13 August 2018

**Section 4.55(1A) Modification to Amend SSD 6848 Lismore Base Hospital
Stage 3B Development**

On 1 May 2015, Stage 3B of the Lismore Base Hospital redevelopment was approved. SSD 6848 has been modified on three (3) occasions (Mod 1, 2 and 3) with a fourth modification application lodged but withdrawn.

Schedule of Changes - Level 3	
Item	Comments
1	Rationalised fire egress strategy
2	Rationalised structure to allow easier turning circles for deliveries
3	Built in under link bridge
4	Extent of demolition rationalised to retain PABX room
5	Additional public lift

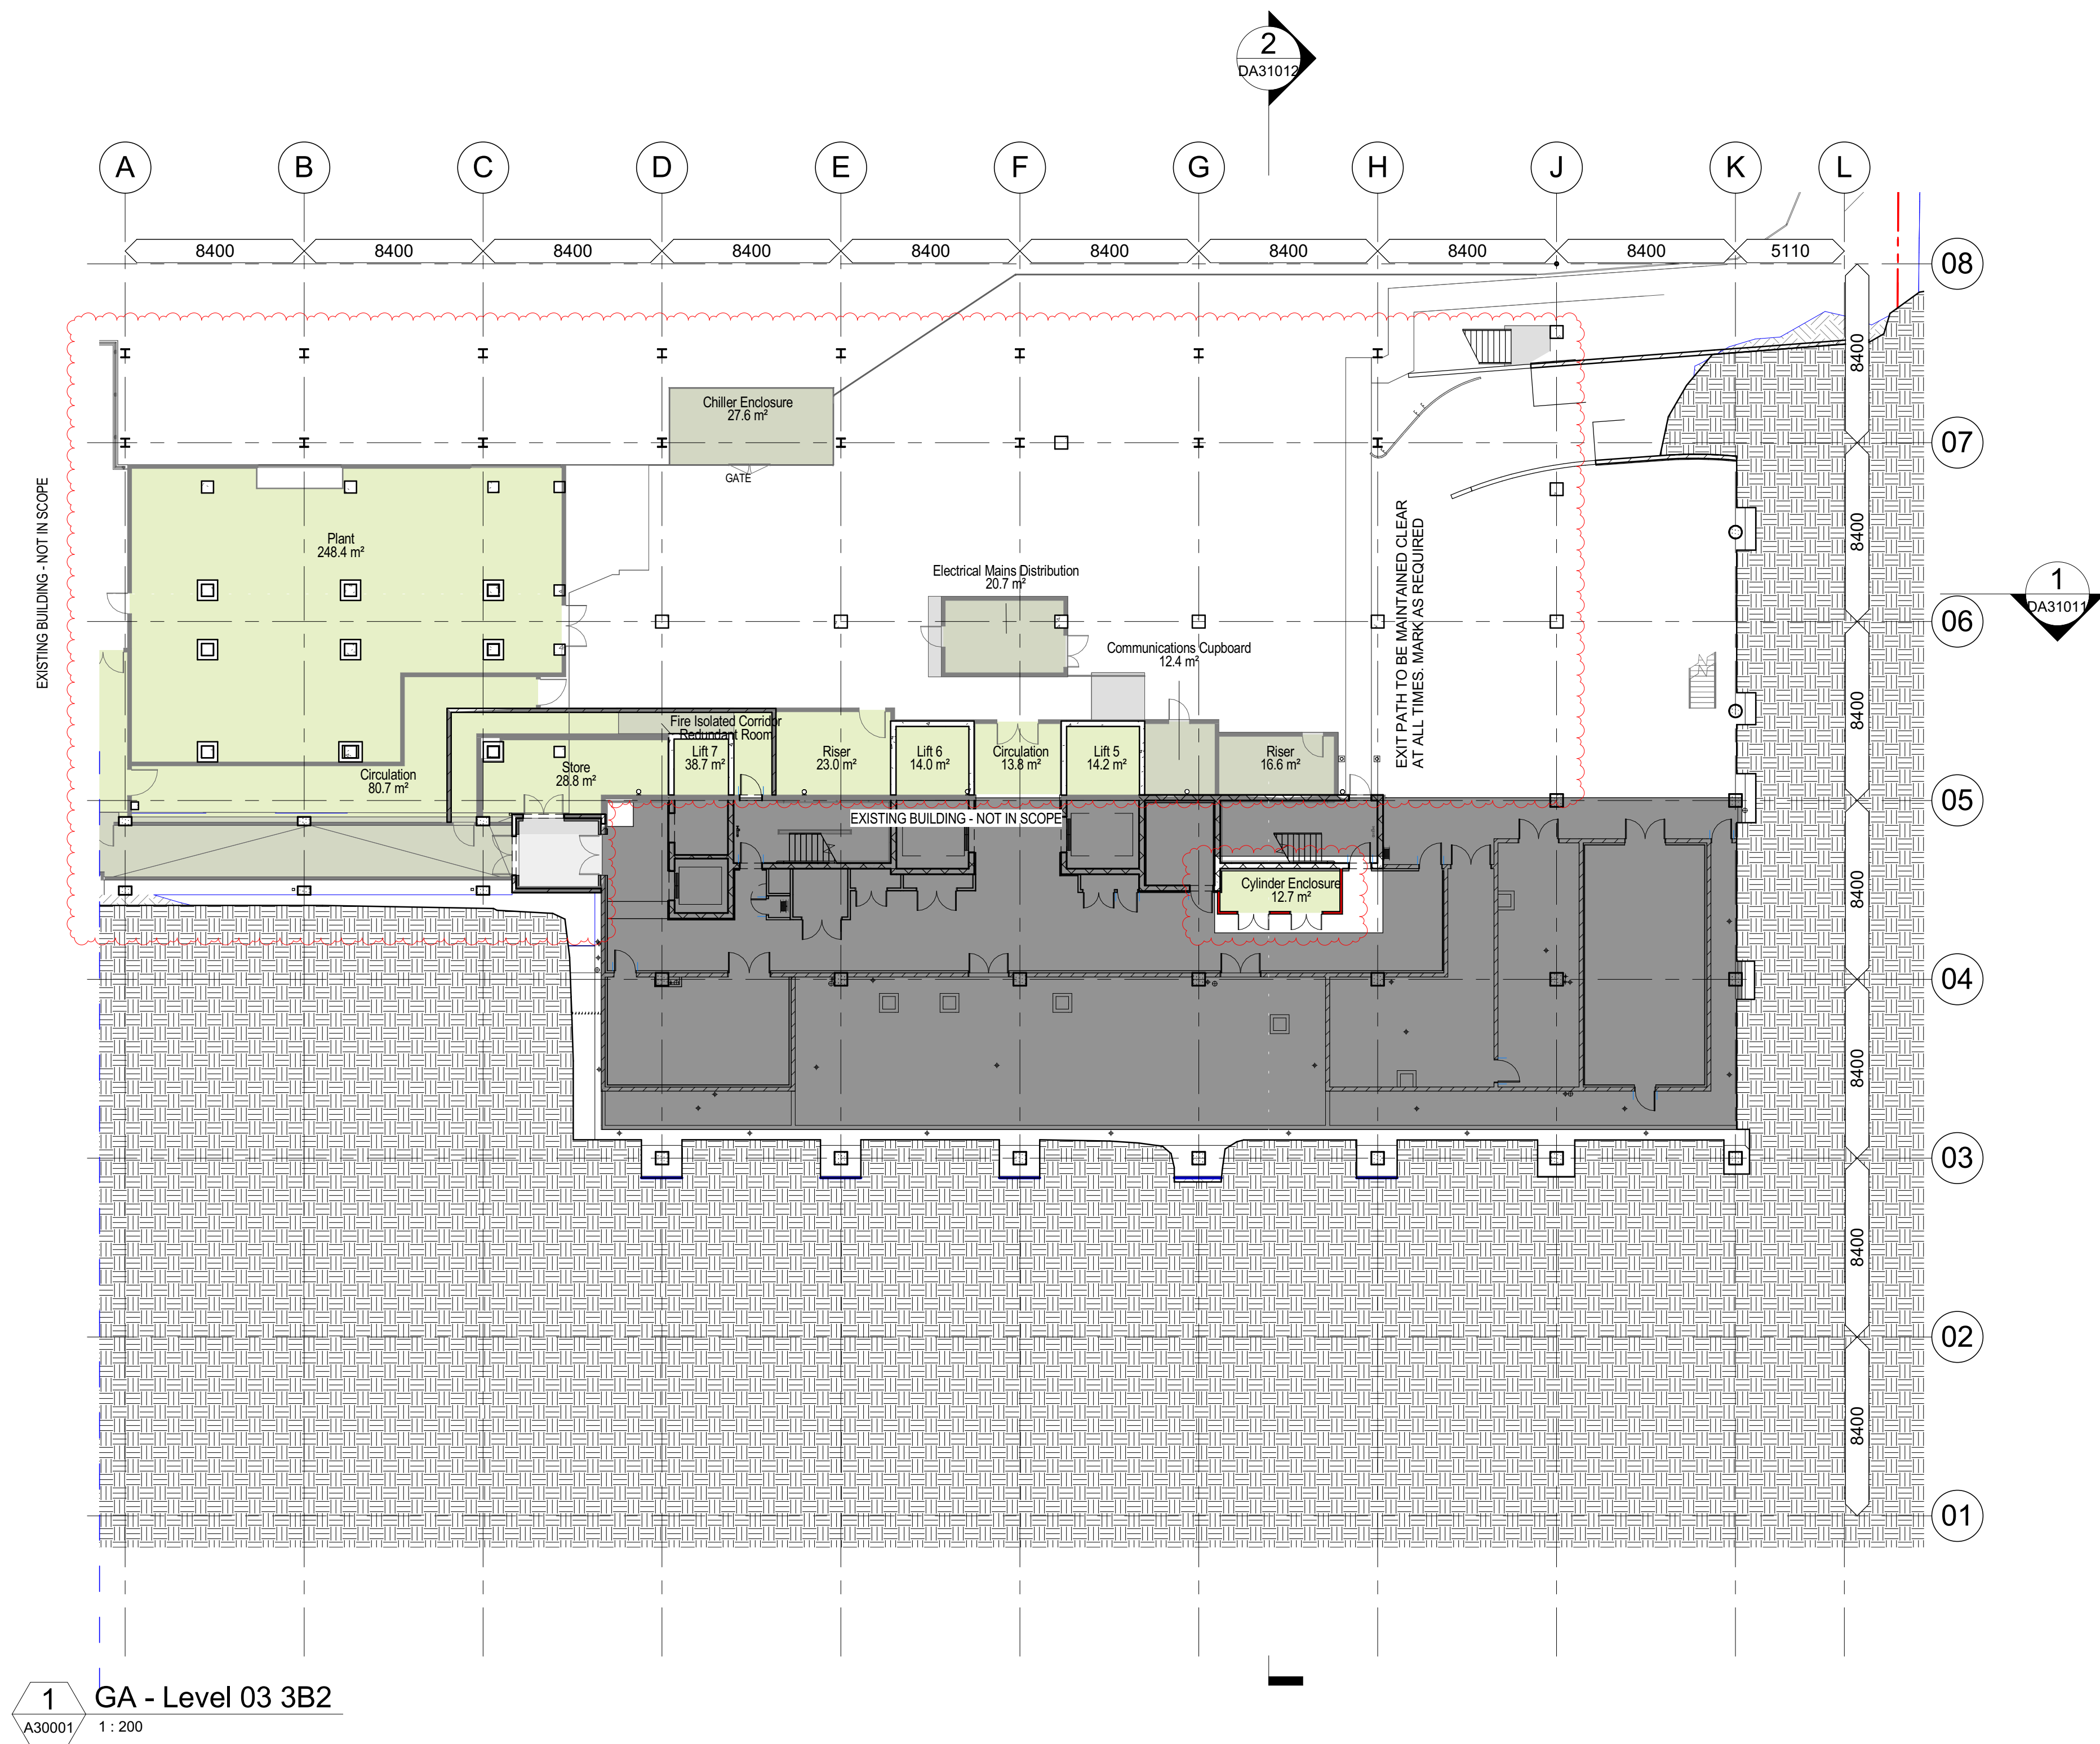
- Reduction in the extent of plant at Level 03, noting that some of this plant has been relocated to Level 07 (within the NTX, the subject of a separate application currently under assessment Department, ref: SSD 17_8963). The use of this area for maintenance will remain unchanged.
